**RE: Sundance Construction – Beverly Hills
Conceptual Grading Plan
Engineer's Stamp Date: No Stamp Date
Hydrology File: B18D023**

Based upon the information provided in your submittal received 12/06/17, the Conceptual Grading Plan **is not** approved for Site Plan for Building Permit. The following comments need to be addressed for approval of the above referenced project:

**RE: Sundance Construction – Beverly Hills
Conceptual Grading Plan
Engineers Stamp Date: No Stamp Date
Hydrology File: B18D023**

A1 FLOOD ZONE MAP
FLOOD ZONE MAP: FMS5001C0129H

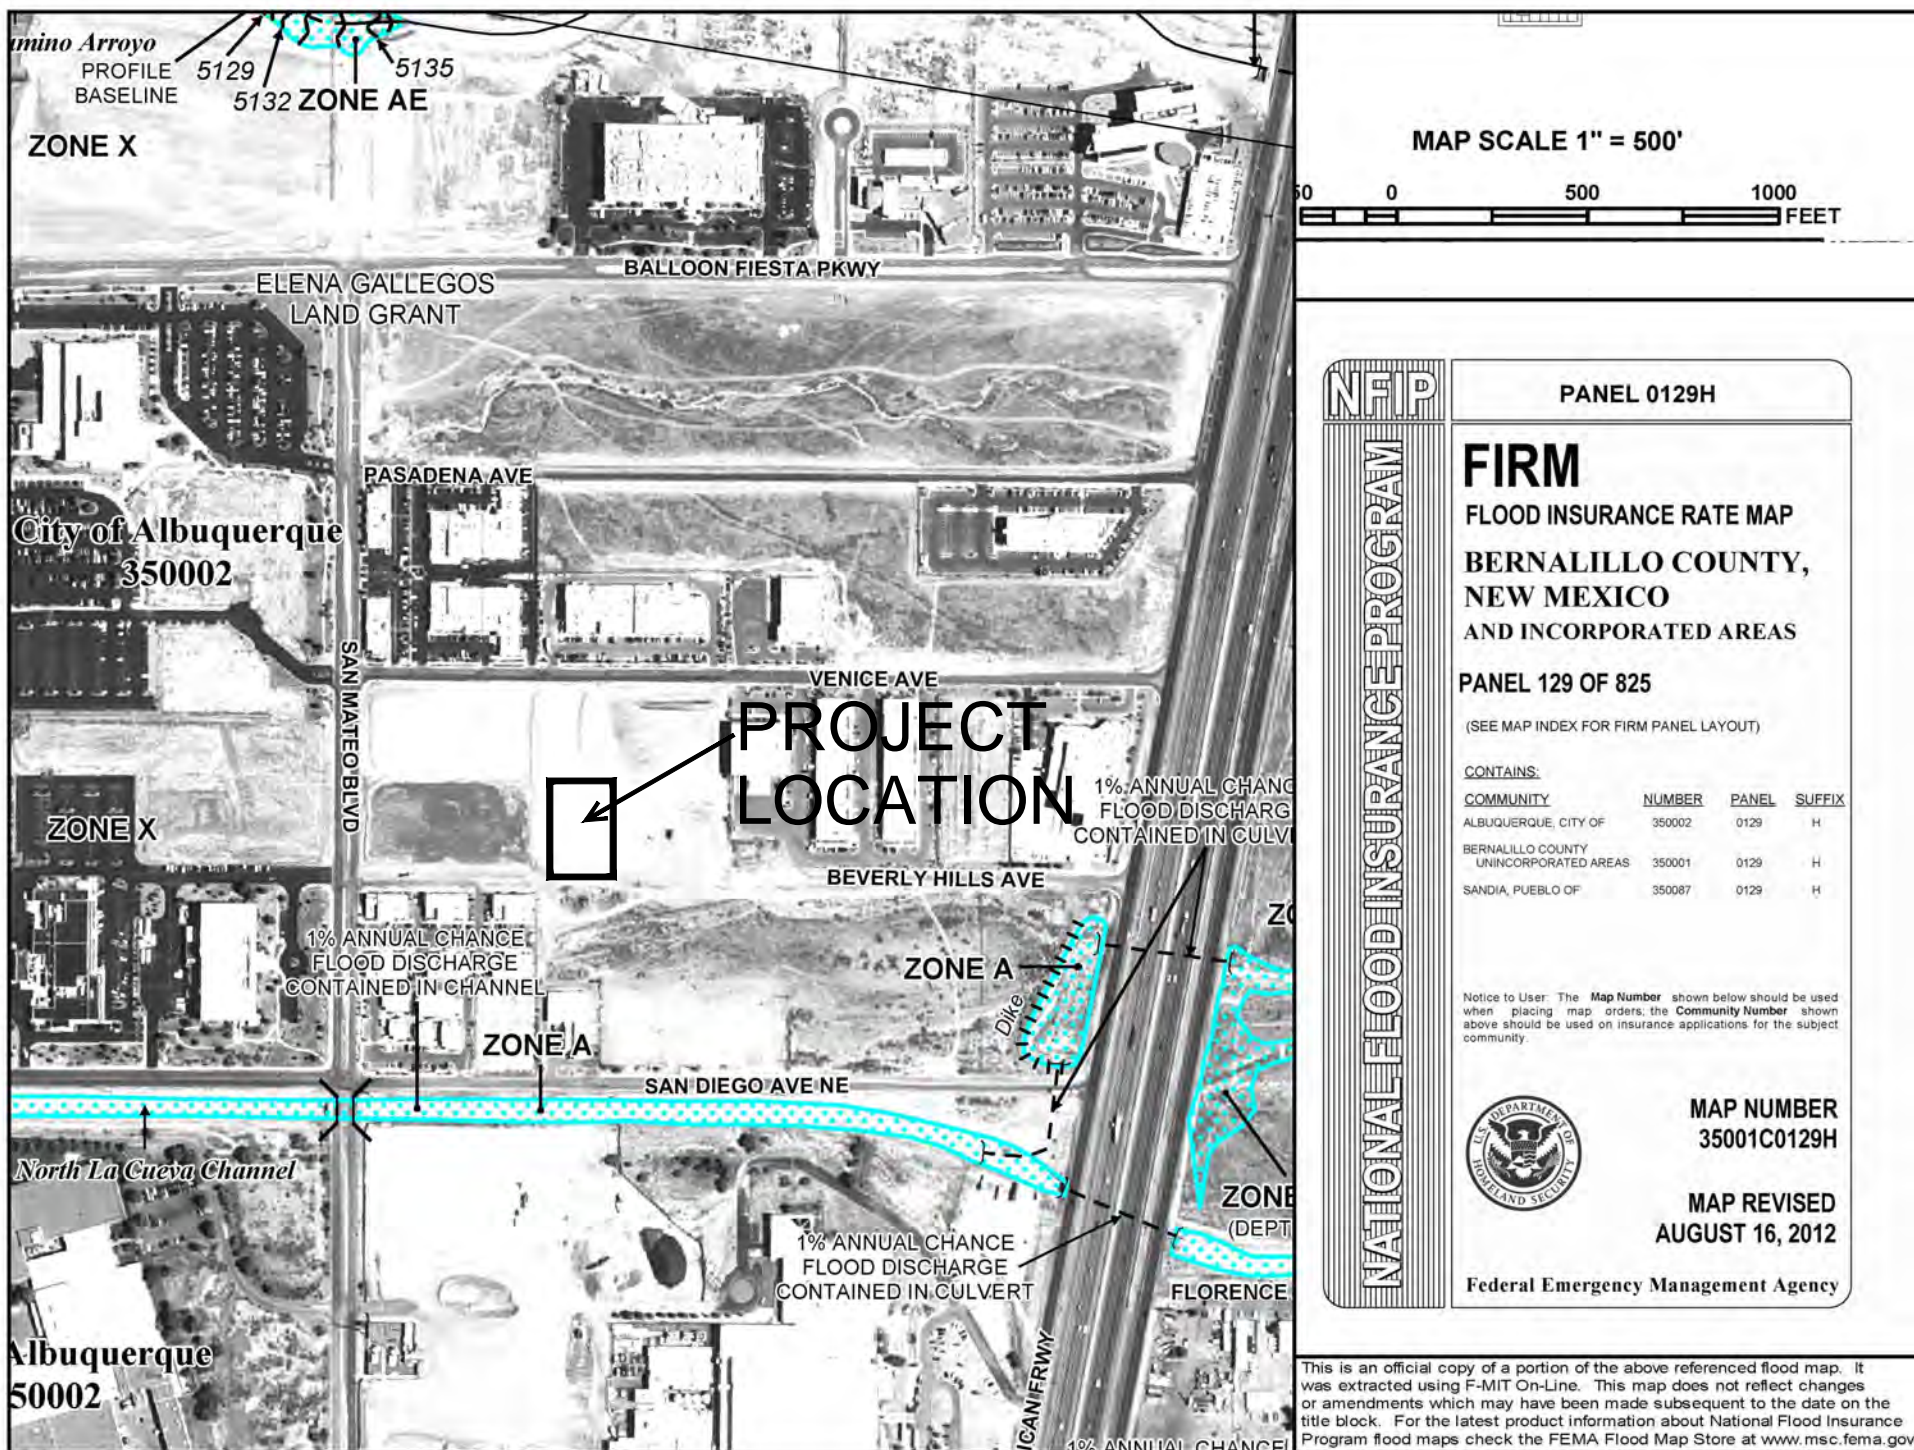
1. Please provide the FIRM Map and flood plain note with effective date.
2. Please provide a vicinity map showing the location of the site. Typically this is the Zone Atlas. This can be downloaded in pdf format from the City of Albuquerque's website.

See attached revised Conceptual Grading & Drainage Plan.

2. Please provide a vicinity map showing the location of the site. Typically, this is the Zone Atlas. This can be downloaded in pdf format from the City of Albuquerque's website.

See attached revised Conceptual Grading & Drainage Plan.

C-100

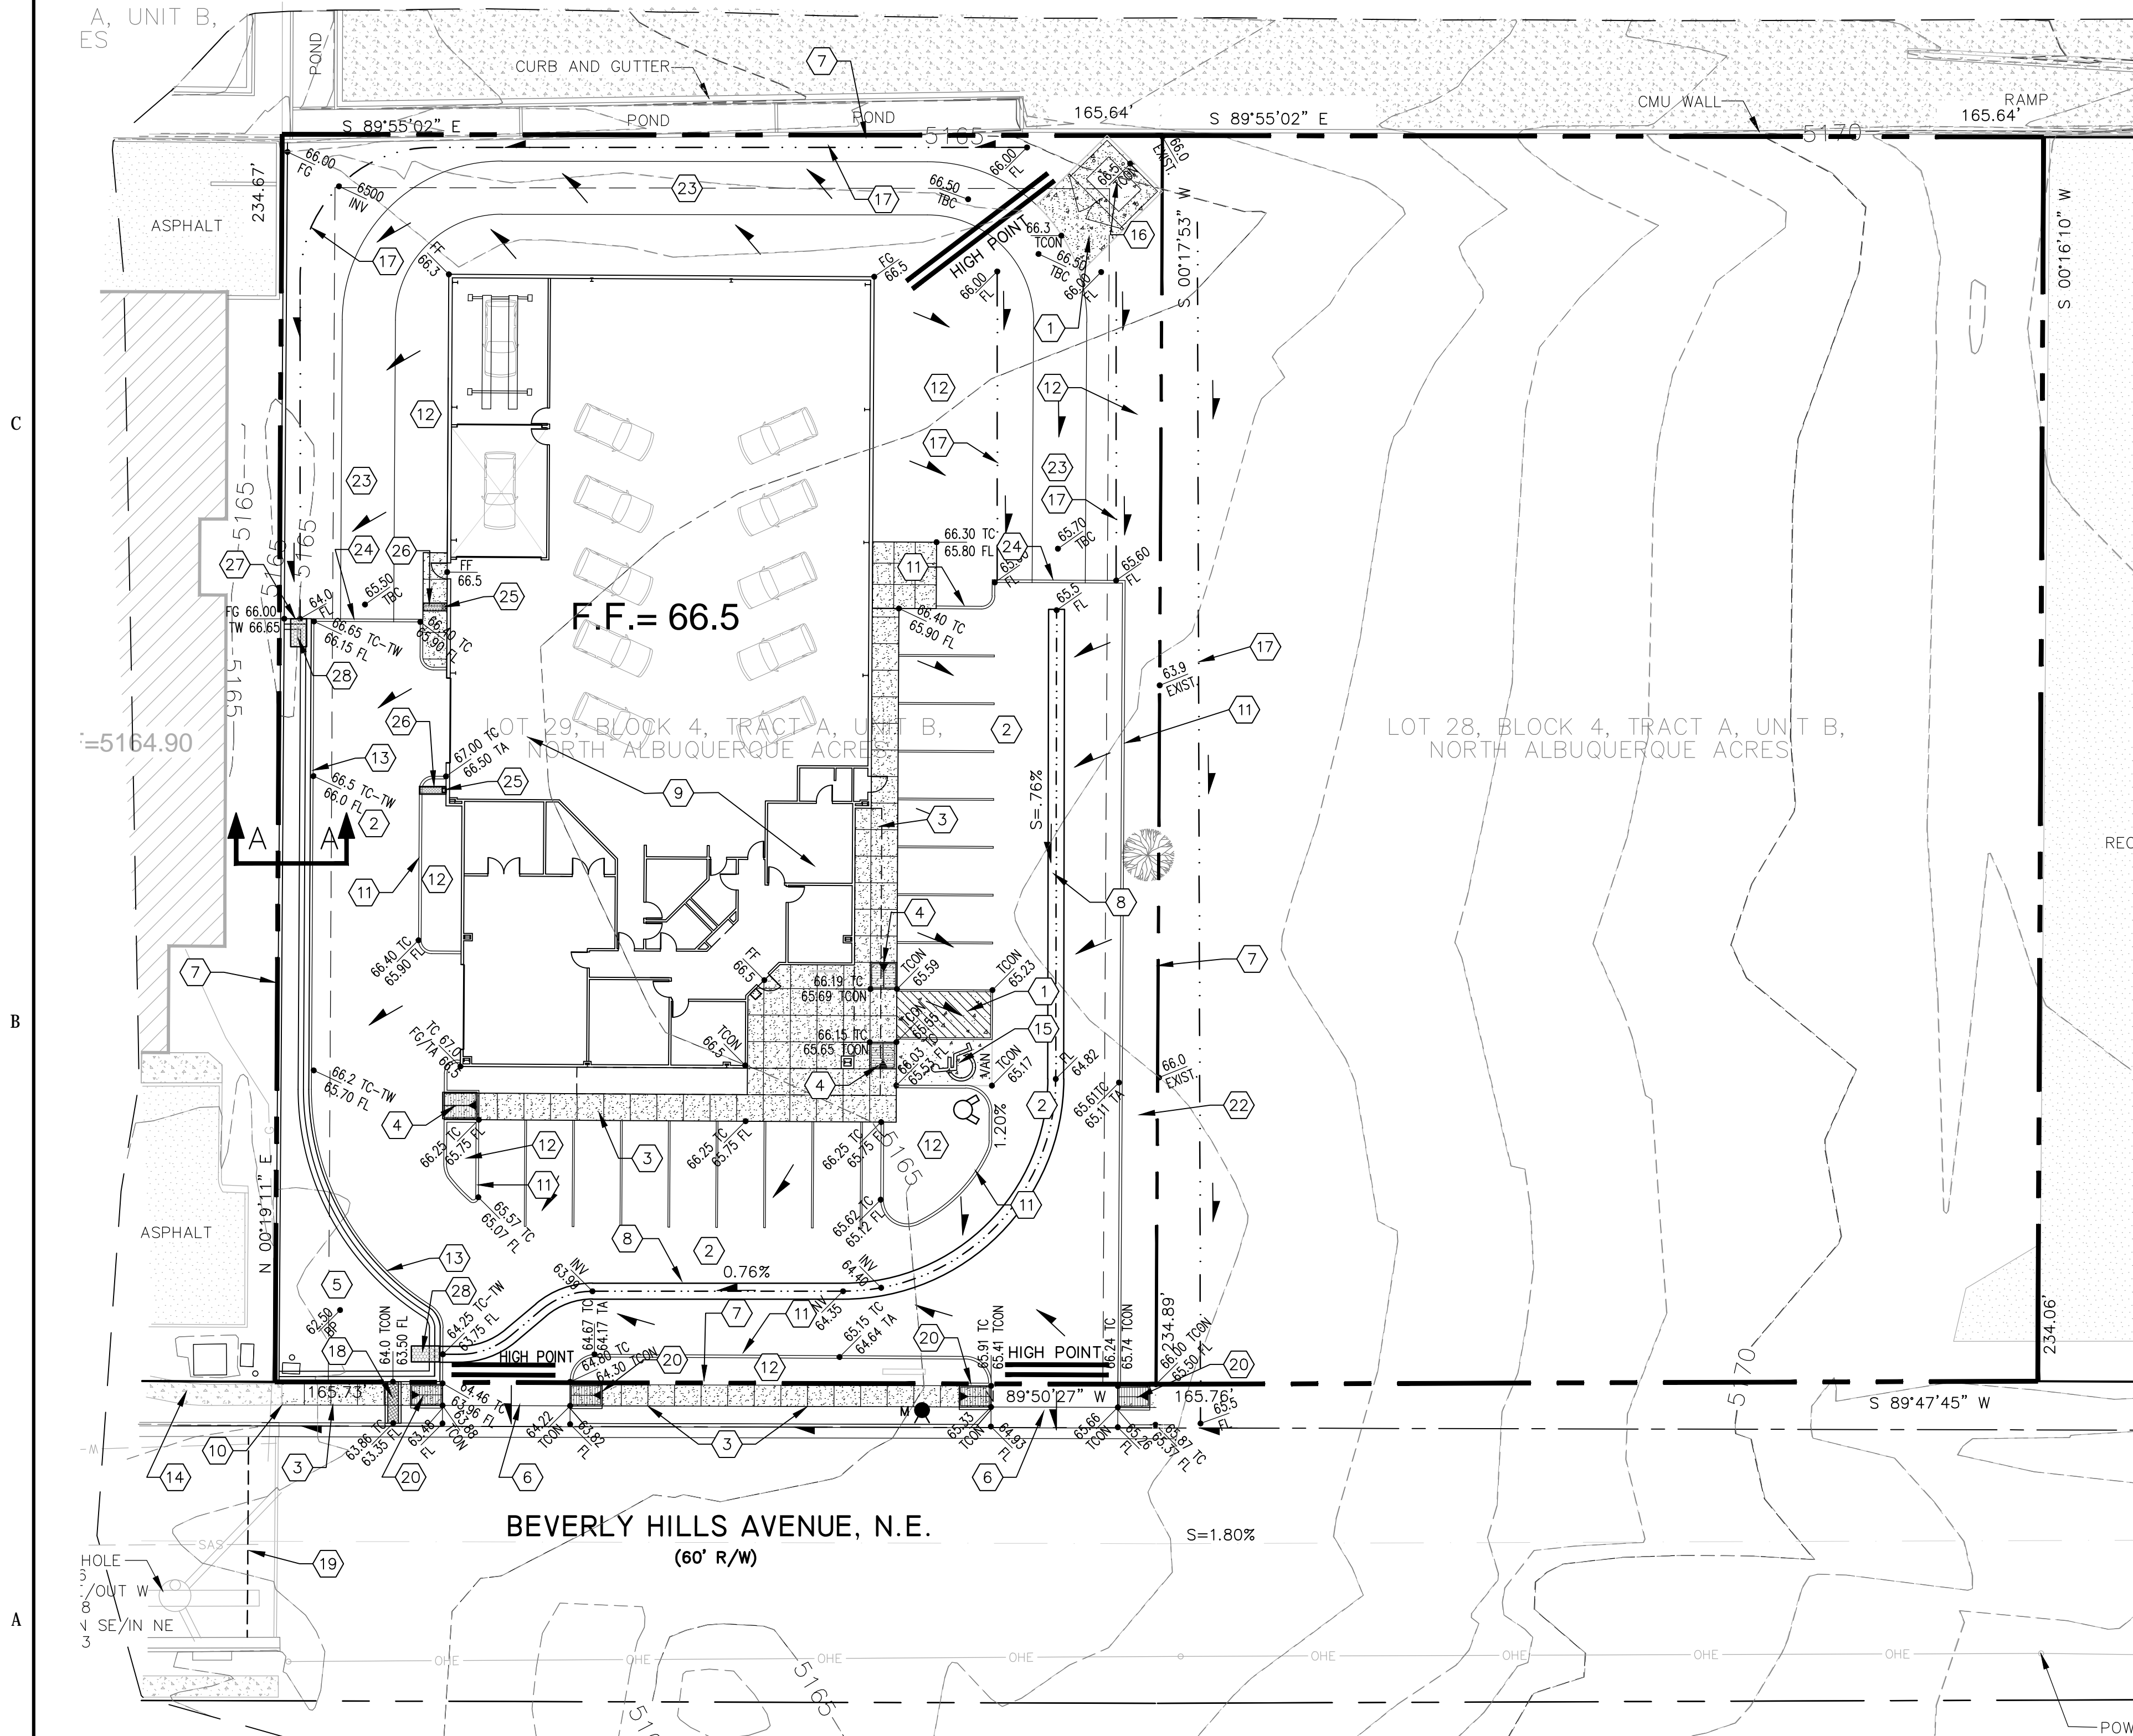
3. Please review the upstream watershed for Beverly Hills Ave. These drainage areas should include all upstream discharges per their ultimate design. Per Chapter 22 Section 3 E (Street Hydraulics) of the DPM, the calculations are for the 10 year and 100 year storm event. The existing 36 inch storm sewer may need to be extended if future inlets are need where the future flows exceeds the street capacity. Also, the existing 18 inch storm sewer may need to be extended to the southwest corner of the tract with a new inlet. If needed, these storm sewer items will have to be included in the Infrastructure List which will be submitted during the DRB action.

The proposed storm drain system is included in the Infrastructure list which will be submitted as part of the DRB submittal and attached herein. The design for the storm drain system was based on City Project Number 637181 – Beverly Hills Ave & Venice Ave Office/Warehouse project by Isaacson & Arfman, P.A. (stamped by Fred Arfman PE #

7322 on 8/14/2000 and approved by the City Engineer in August 2000). These plans show a future 36" RCP crossing the frontage of Lot 29 with future curb inlets placed on the north side of Beverly Hills Ave. just east of the west property line of Lot 29 and just west of the east property line of lot 30 (already installed). These plans also have Q's for the proposed storm drain system. See attached plans

The 36" existing storm drain that has been constructed west of our site (Lot 29) is a 36" RCP. There is an existing Manhole just west of Lot 29 with a 36" RCP stubbed out just past the end of the existing pavement at the west property line of our site. This existing storm drain system is based on Project No. 722081 Beverly Hills Ave Paving and Utility Improvements project by Advanced Engineering and Consulting, LLC (stamped by Shahab Biazar PE # 13479 on 8/25/2005 and approved by the City Engineer in Dec. 2004). These plans show a future 36" RCP stub to the west property line Lot 29. These plans also have Q's for the proposed storm drain system that match the Q's on the plans mentioned above by Fred Arfman. See Attached plans.
